## **Colorado Springs, CO**

### **Final Report - Corrections Required** **Application No. ANEX-24-0006**

**Description : Matrix Design Group on behalf of Colorado Springs Equities LLC is submitting a serial annexation petition for seven parcels and Land Use Plan/Rezoning exhibit for a portion of the subdivision known as Rock Creek Mesa.**

**Document Filename : Rock Creek Mesa Addition 5\_Petition\_V3\_5-13-24**

## ROCK CREEK MESA ADDITION NO. 5

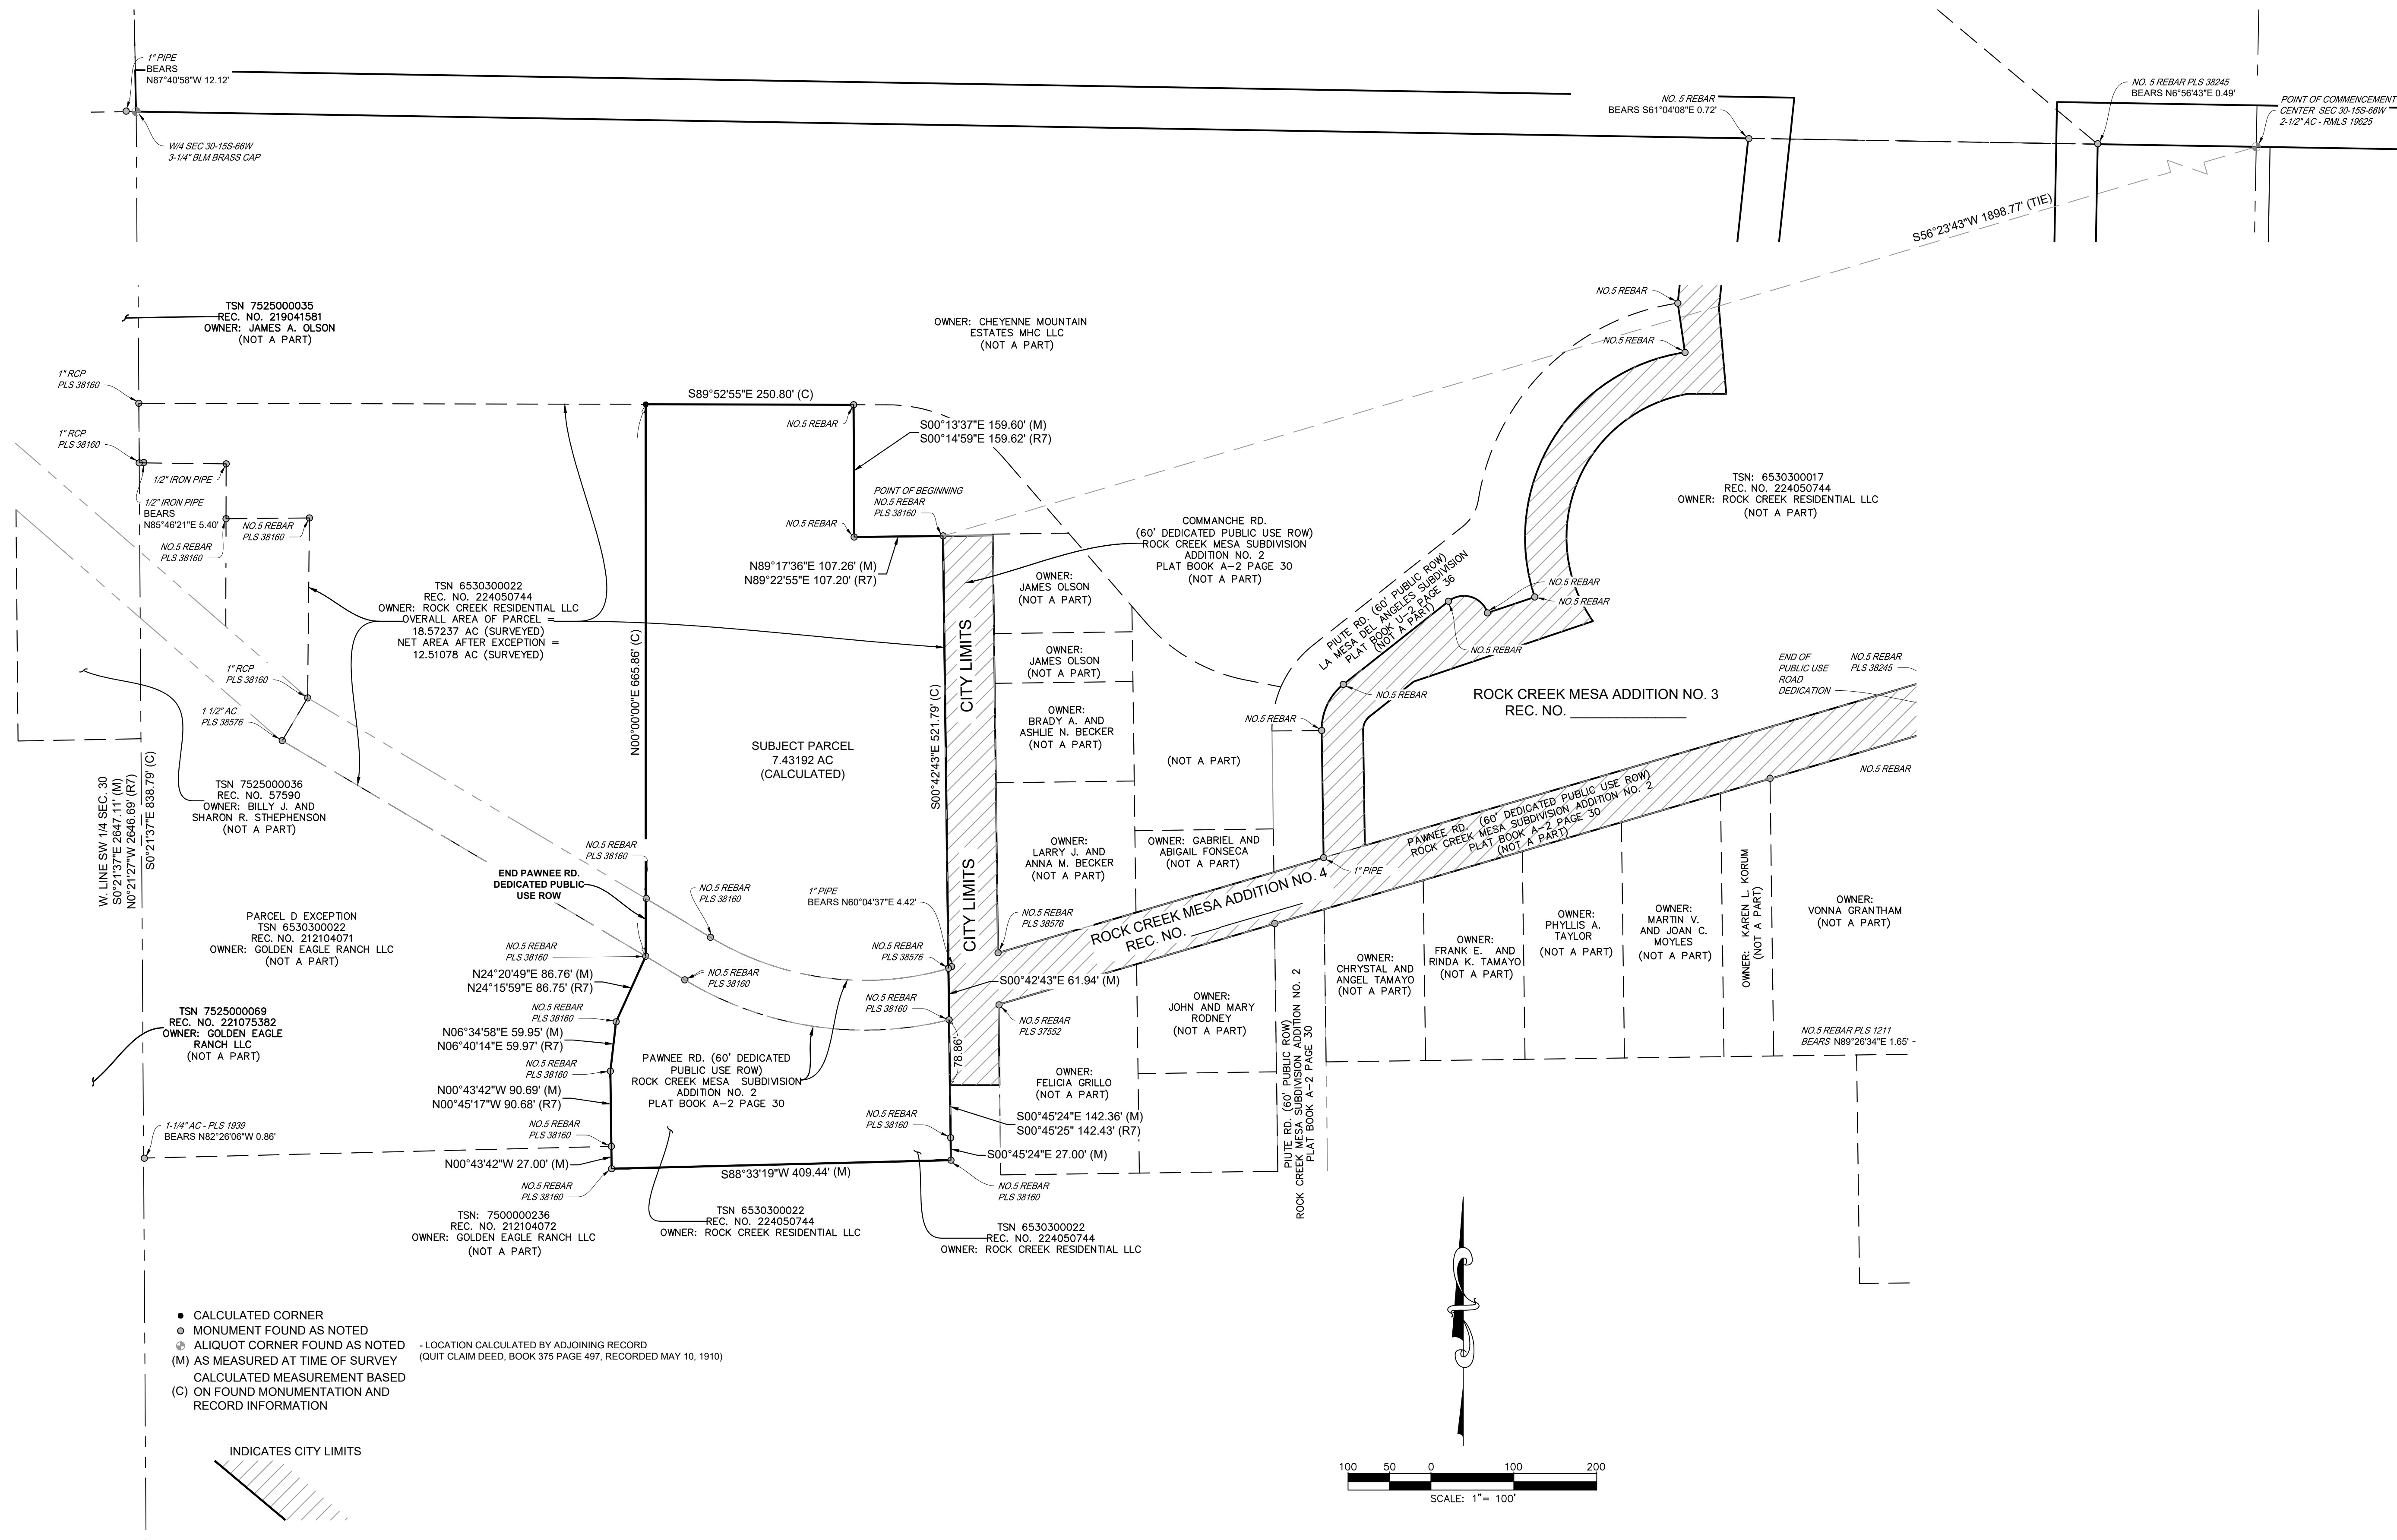
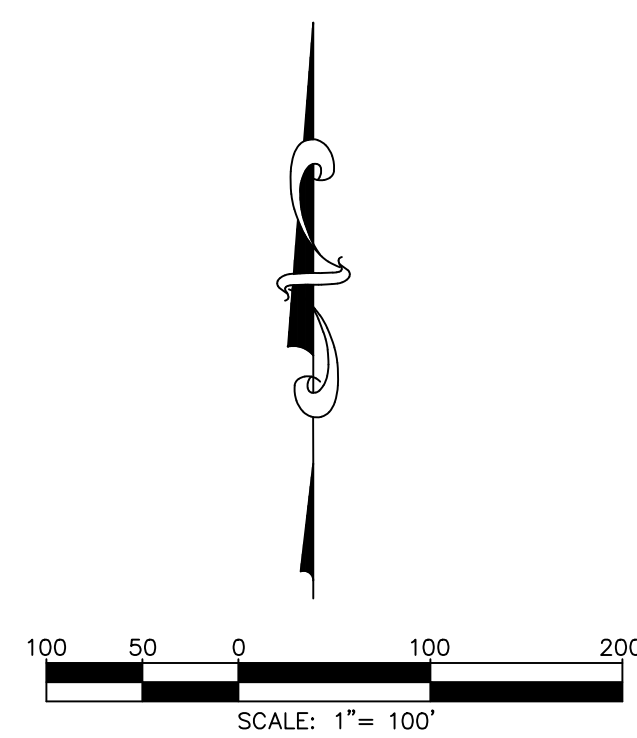
<b>Comment ID</b>	<b>Page Reference</b>	<b>Reviewer : Department</b>	<b>Review Comments</b>
46	1	Gabe Sevigny : Planning	Update legal description per Surveyor comments
